From: Amanda Scholes on behalf of Planning.Responses
Sent: 16 March 2018 08:19
To: Planning Scanning
Subject: FW: A/3/18/PL - Land at Arundel Road/A27, Angmering - Change of use of land to storage (B8 Storage or Distribution)

From: Ian Hayward [mailto:ian.hayward@westsussex.gov.uk]
Sent: 14 March 2018 10:06
To: Ross Leal
Subject: RE: A/3/18/PL - Land at Arundel Road/A27, Angmering - Change of use of land to storage (B8 Storage or Distribution)

Title:
Site Access with Southern Visibility Splay

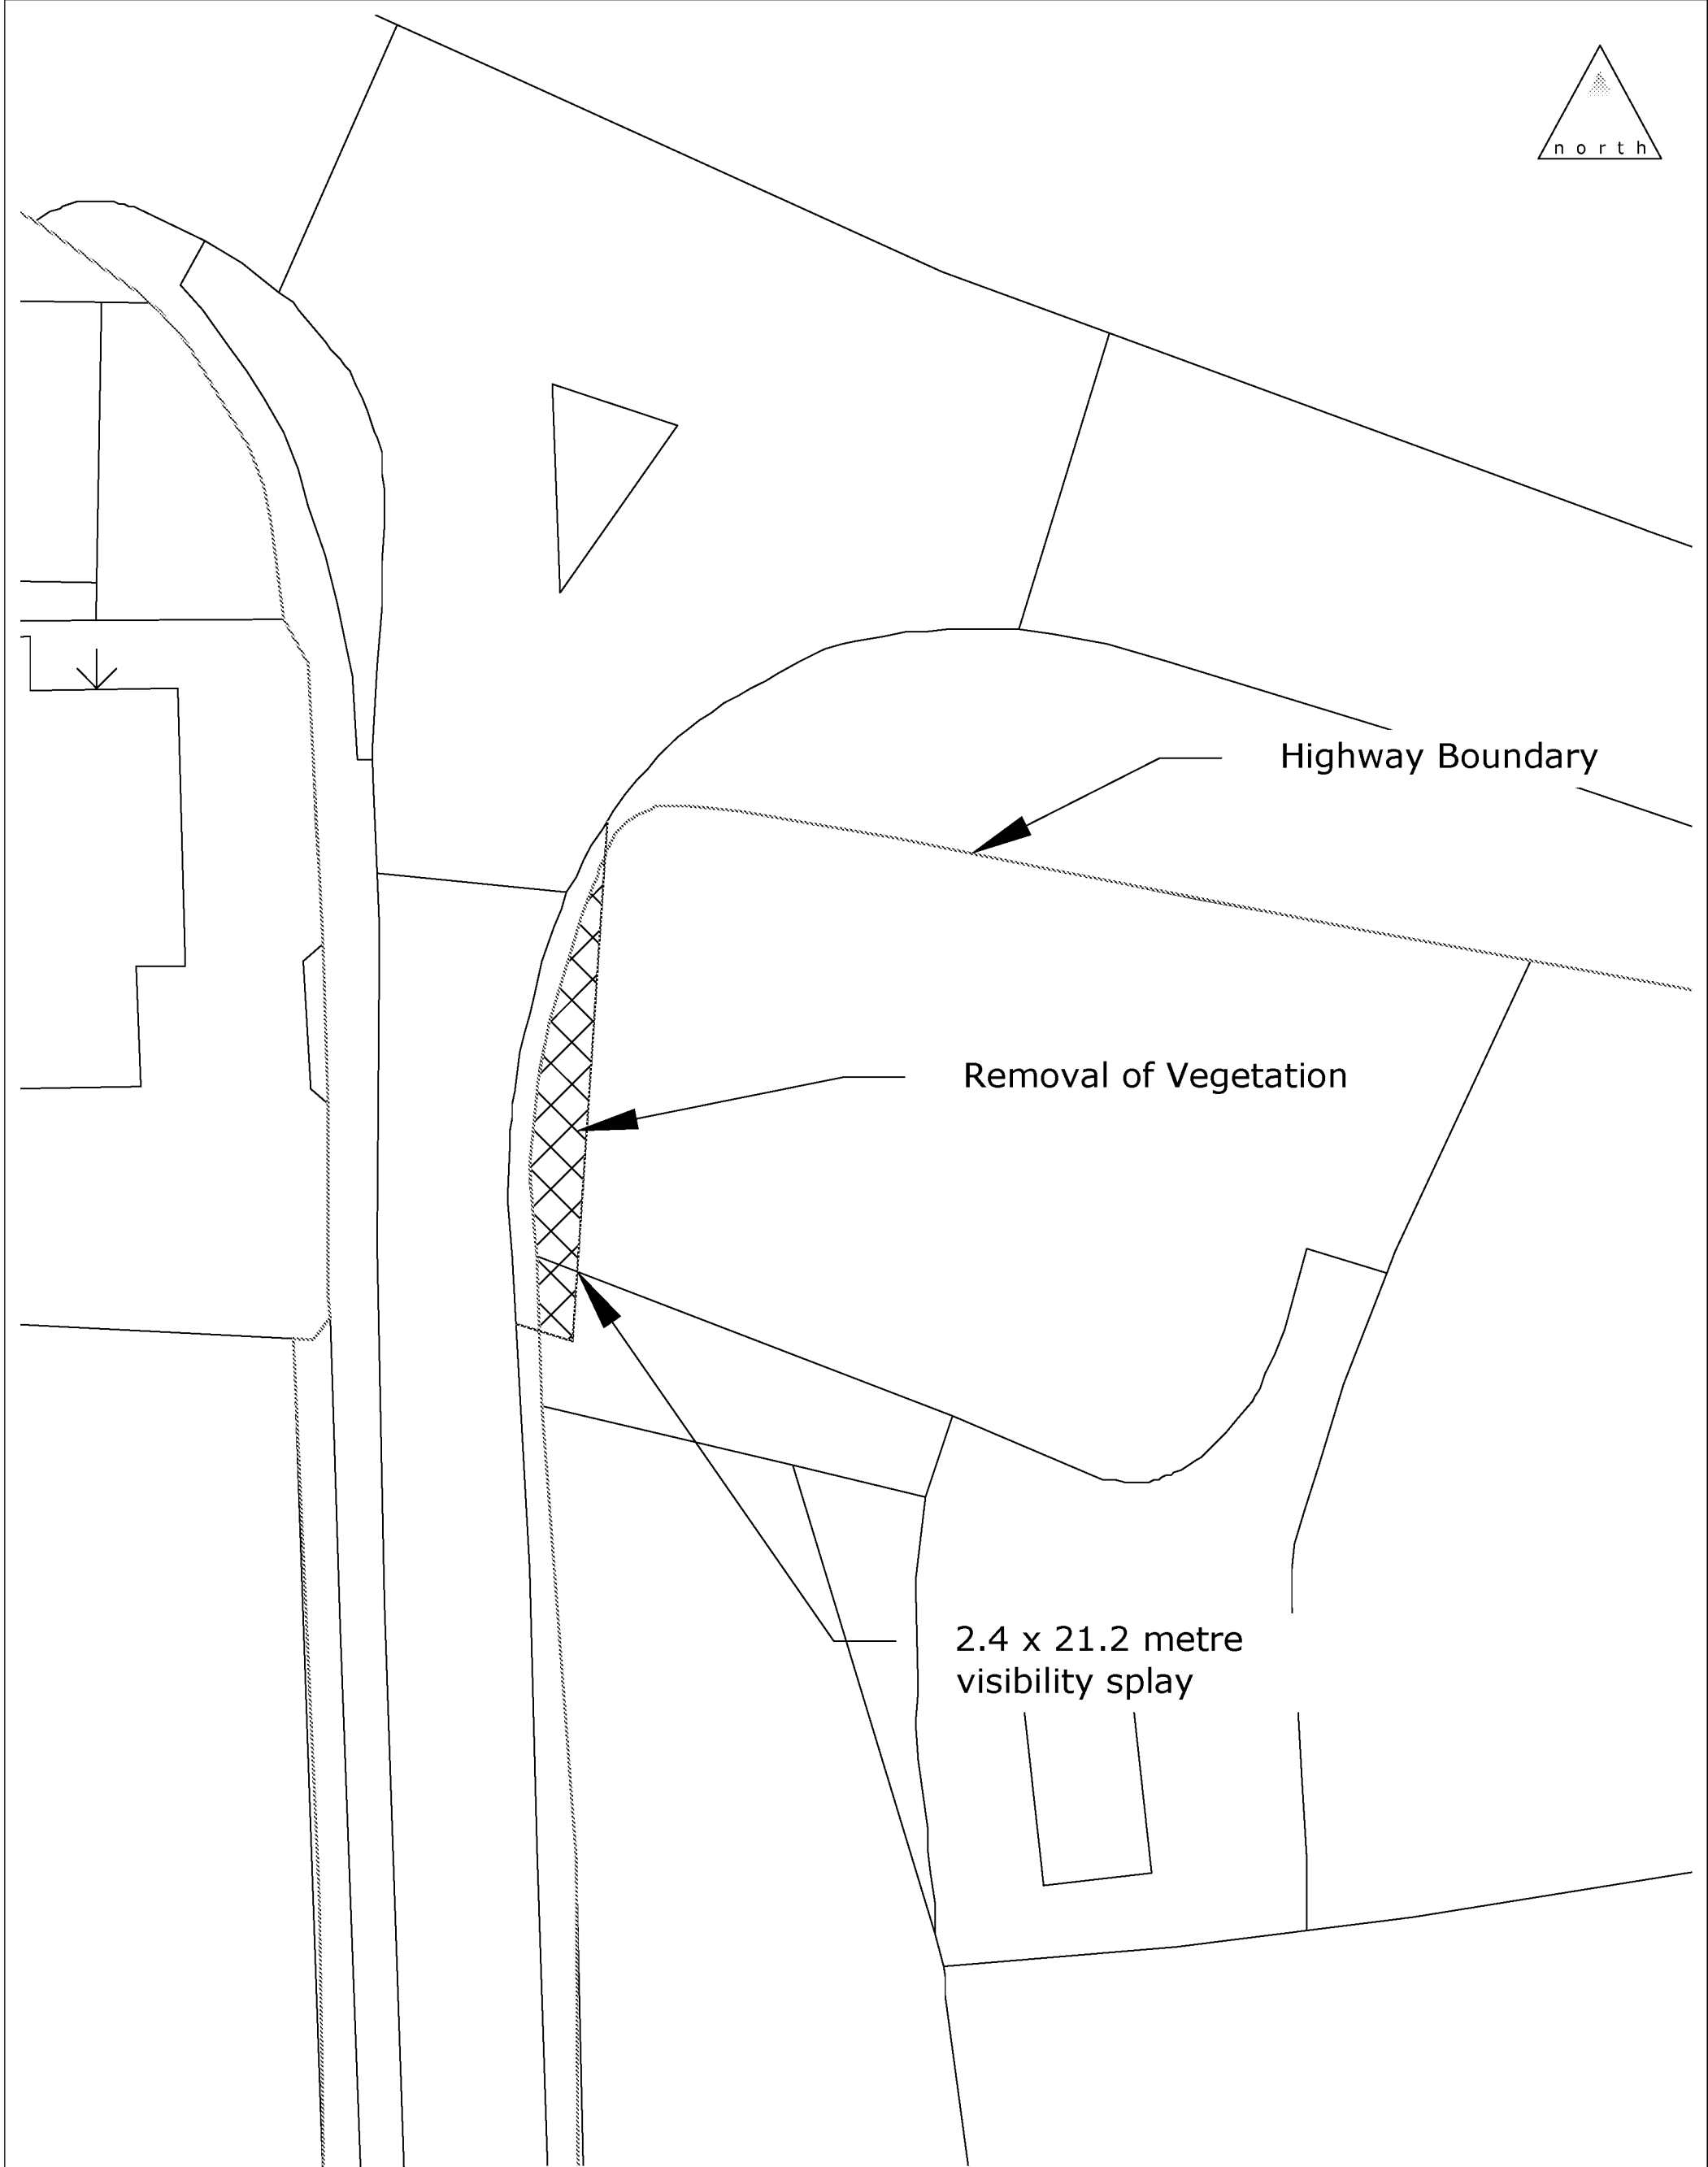
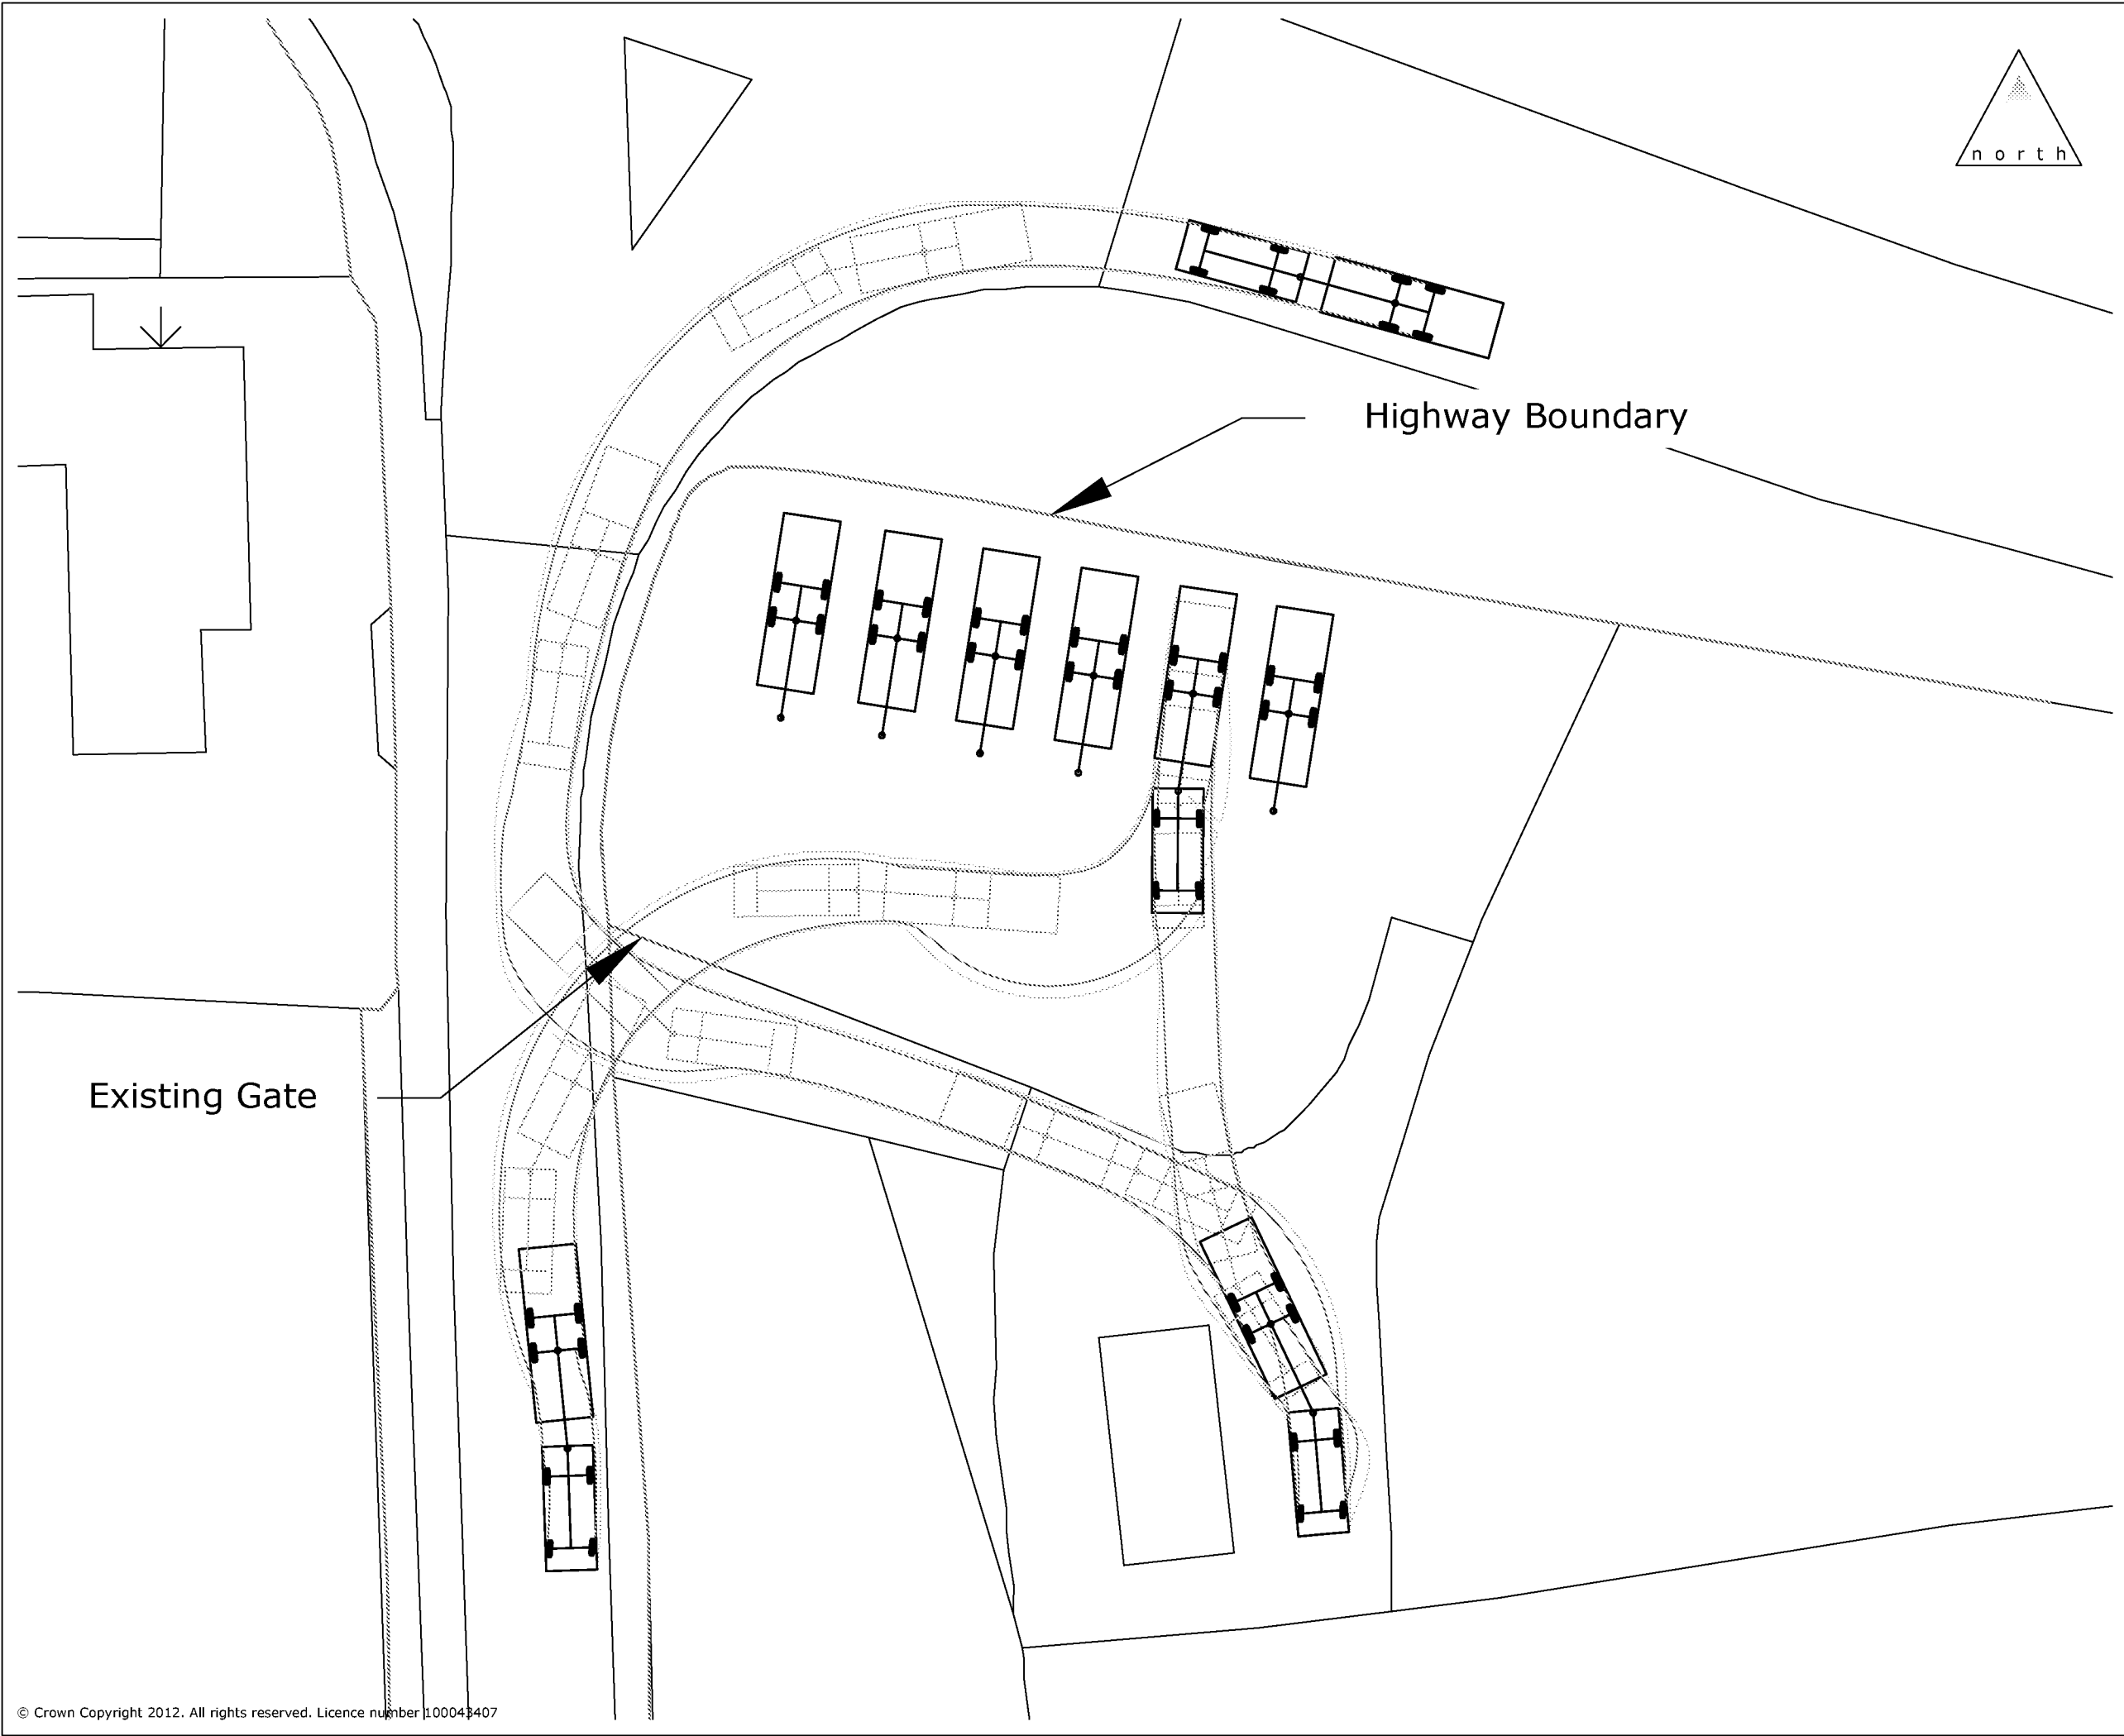
I don't see how appropriate visibility splays can be created south (trailing direction) without the use of 3rd party land. While I would accept that appropriate visibility splays to the north can be created as per the data provided the formation of these splays may be unacceptable to the Local Planning Authority due to the amount of vegetation and

- If we were to go down the route of not removing the hedging / vegetation to create the visibility splays, but simply lowering them they would need to be reduced in height to 0.6 metres, given there is no footway in this location there would be some scope that any lowering could be to 0.8 / 0.9 metres as the height of a drivers eye in a private motor vehicle is accepted as being 1.05 metres. Regardless this is going to have a significant impact on the street scene which would be a consideration for you.
